Application Ref: H08-0842-26

Proposal: **Details of vehicular access & dimensions of private drive, refuse collection point, surface water disposal, scheme of landscaping & tree planting, boundary treatments, nest bricks, bat boxes & owl box (Conditions 4, 5, 7, 8, 9 & 10 of H08-0023-26)**

Location: **Land at Boston Road, Gosberton, Spalding**

PROJECT | Residential Development,
Boston Road,
Gosberton,
Lincs.
DATE | November 2025
TITLE | Site Plans
SCALE | 1:500 / 1:1250
ORIGINAL SIZE | A1
DRG STATUS | PLANNING
DRAWING NUMBER | LDC4539 - 10 A

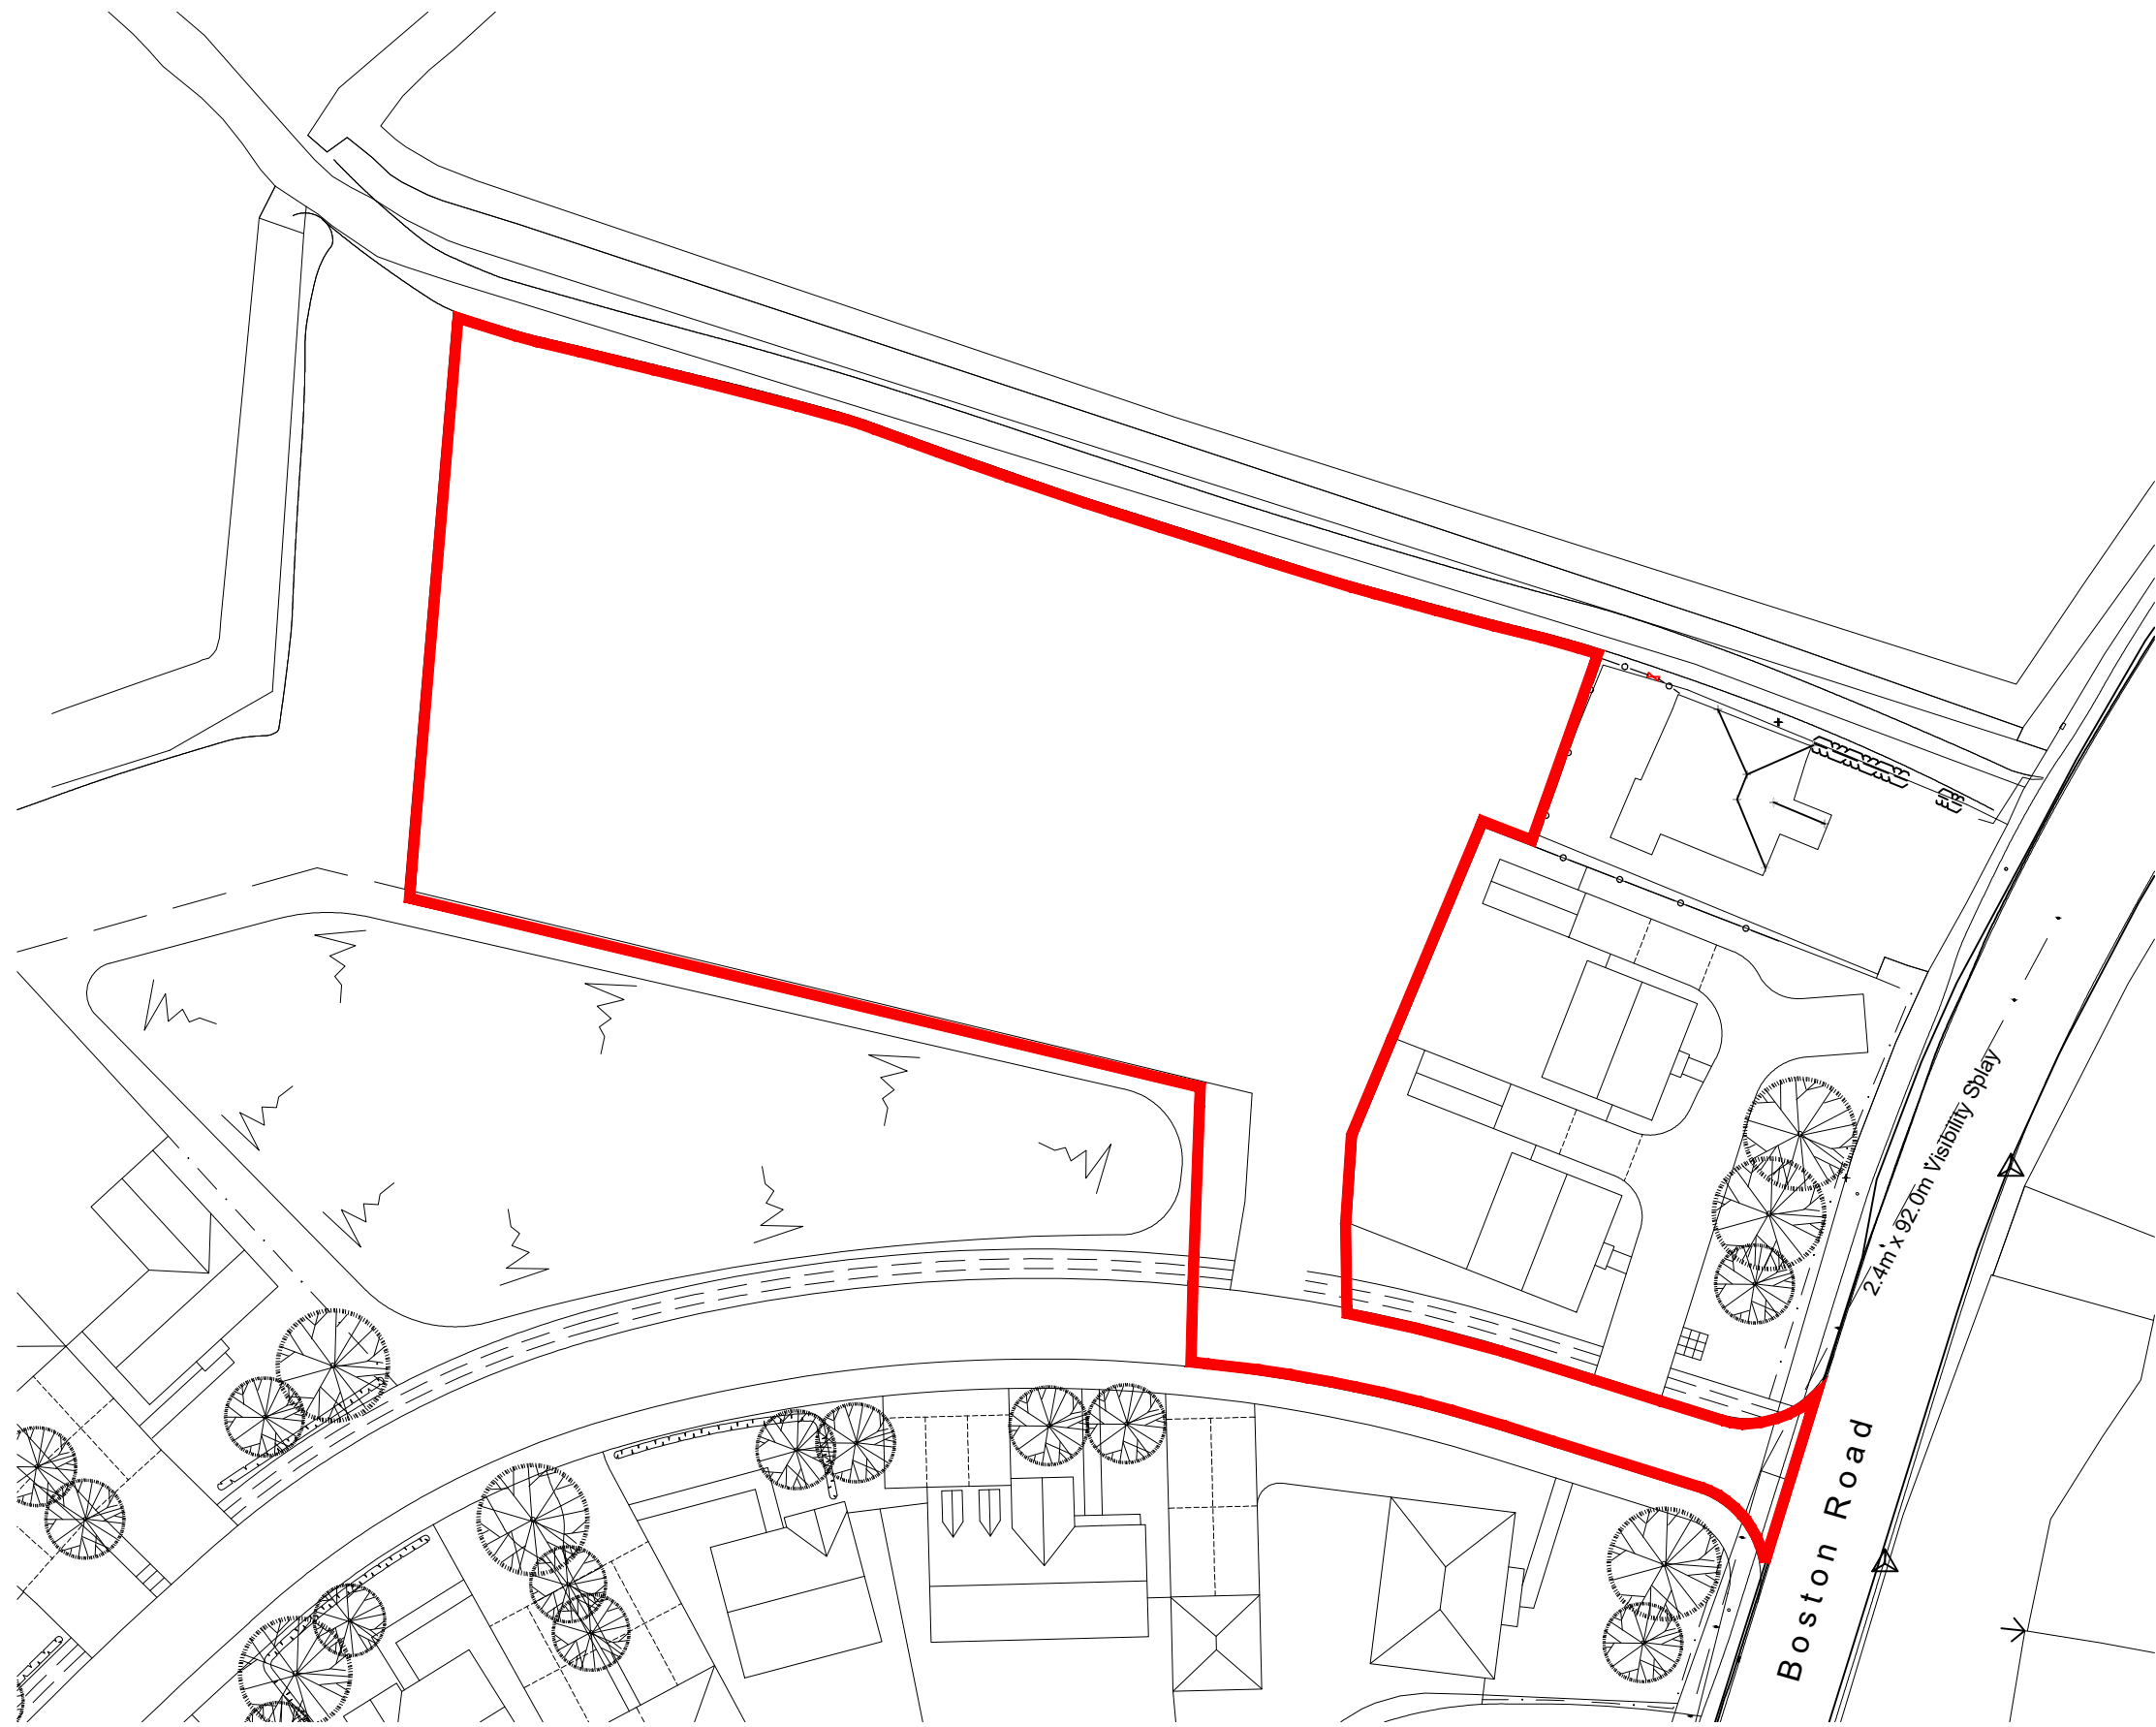
In respect of Condition 4, no dimensions have been provided for the vehicular access or private drive. A fully dimensioned plan should be submitted, including clarification of the proposed construction where the permeable paving crosses the underdrained swale. Please confirm whether a perforated pipe is proposed beneath the access, or if flexible construction and crossfalls are proposed and note that any works affecting the existing Section 104 drainage system or easement will need to be agreed with Anglian Water.

In respect of Condition 5, the refuse collection point does not appear to meet the relevant carry distances. Plots 3 and 4 would require residents to carry refuse more than the recommended maximum distance of 30m. The collection-point slabbing should therefore be moved further into the site to reduce the residents' carry distance, while remaining within 25m of the refuse vehicle. This would also avoid conflict with the existing Section 104 easement.
